OUT16/15284

**Stage 1B Basement, Barangaroo South (SSD 6960)
Comment on the Environmental Impact Statement**

Attachment A
Stage 1B Basement Barangaroo South (SSD 6960)
Comment on Environmental Impact Statement

1 SECTION THROUGH BASEMENTS

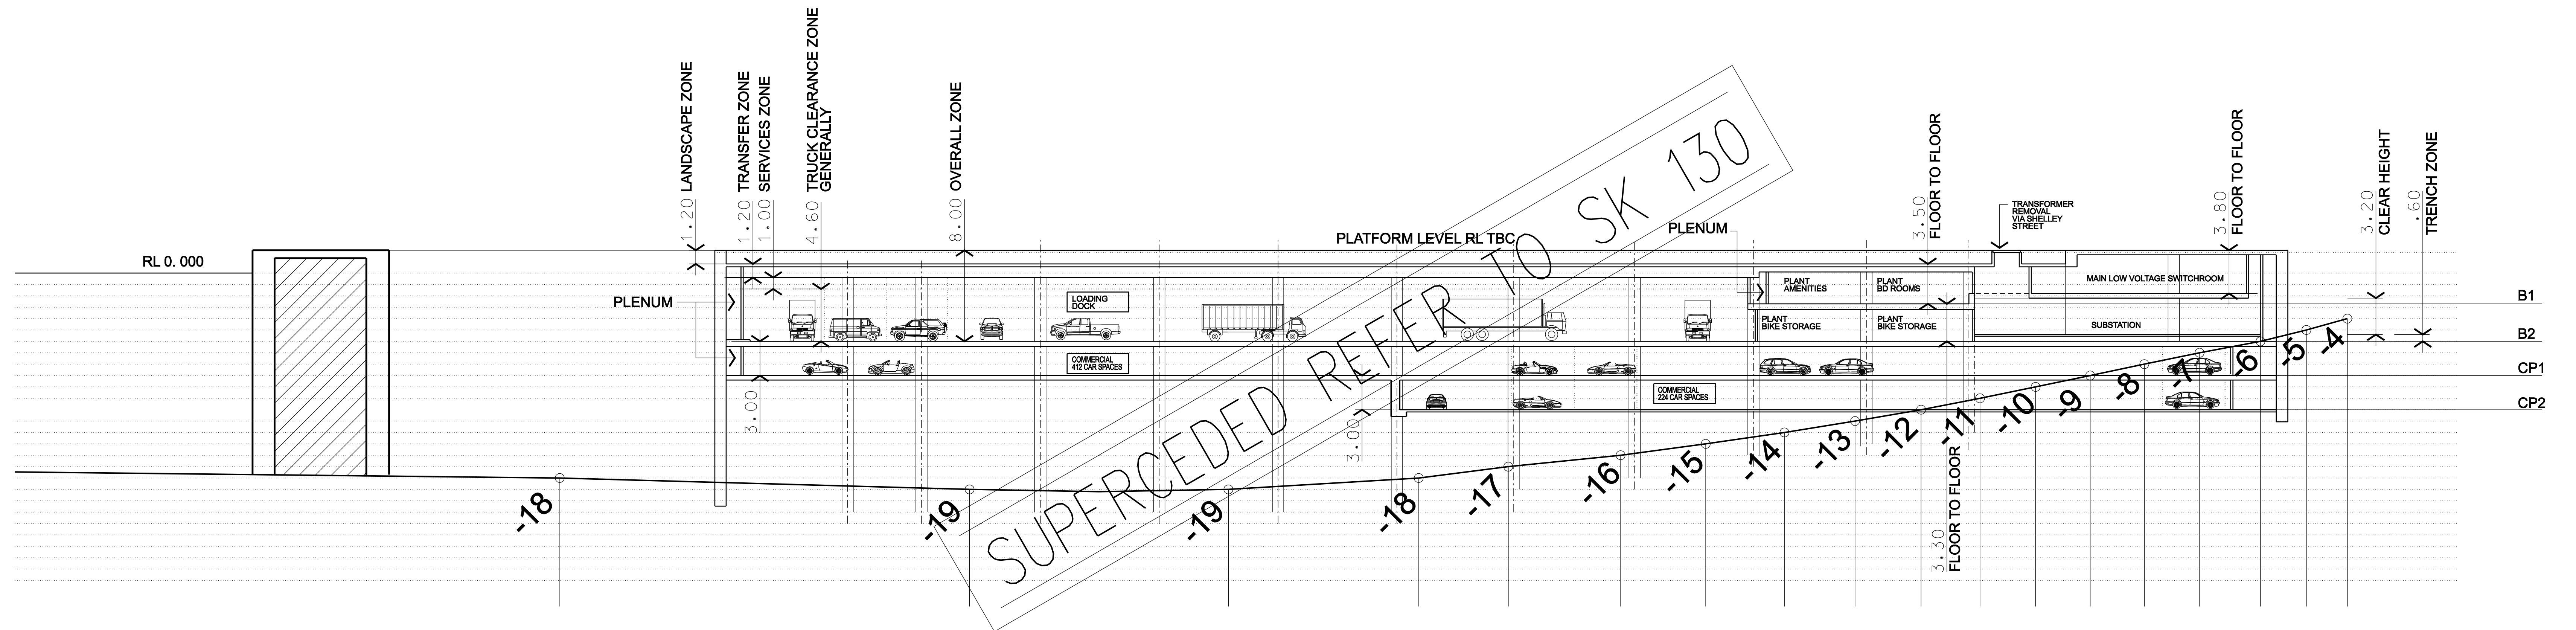
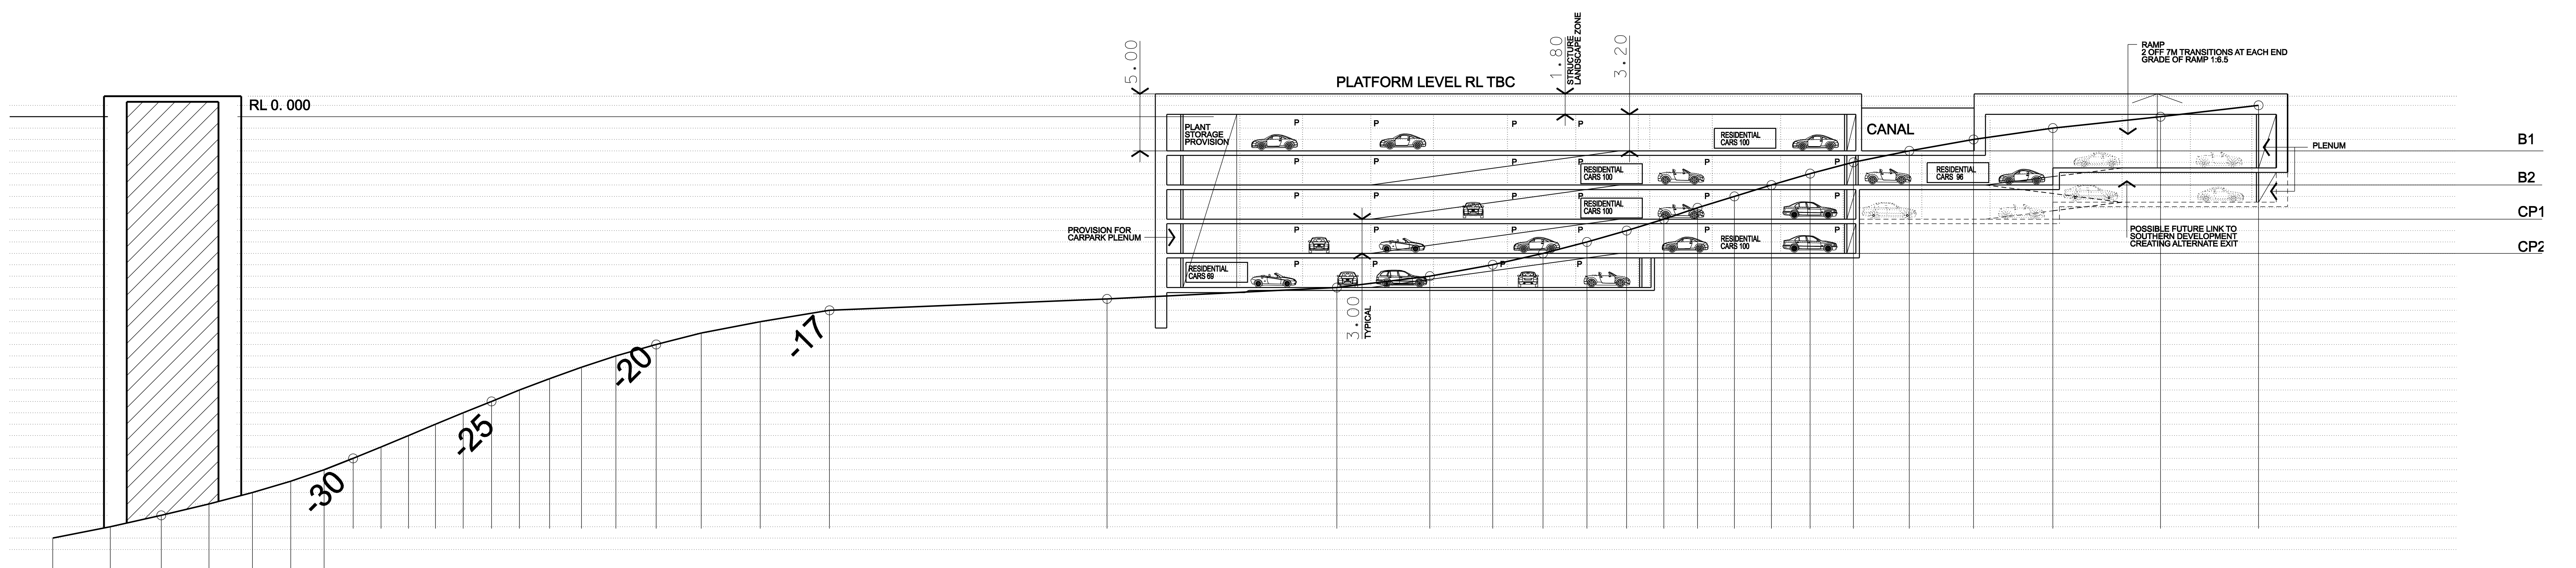
The site is on a part of the western edge of the Sydney Basin Central Groundwater Source, immediately on and above its discharge zone into Darling Harbour. The construction will affect the flow within, and discharge of, the aquifer system. The construction of the major groundwater cut-off/basement wall will have the propensity to:

- impede flow and alter aquifer characteristics and operation
- create mounding of otherwise free discharge
- alter (flatten) the groundwater gradient in the local district.

This issue should be addressed by providing for continuing groundwater discharge either beneath or in or around the construction.

The basement/groundwater cut-off wall is designed to significantly reduce any on-going groundwater ingress. However, the construction is not designed as a fully-tanked basement. It should be expected that there will be some seepage in and around the wall and floor; some of this may be saline from Darling Harbour.
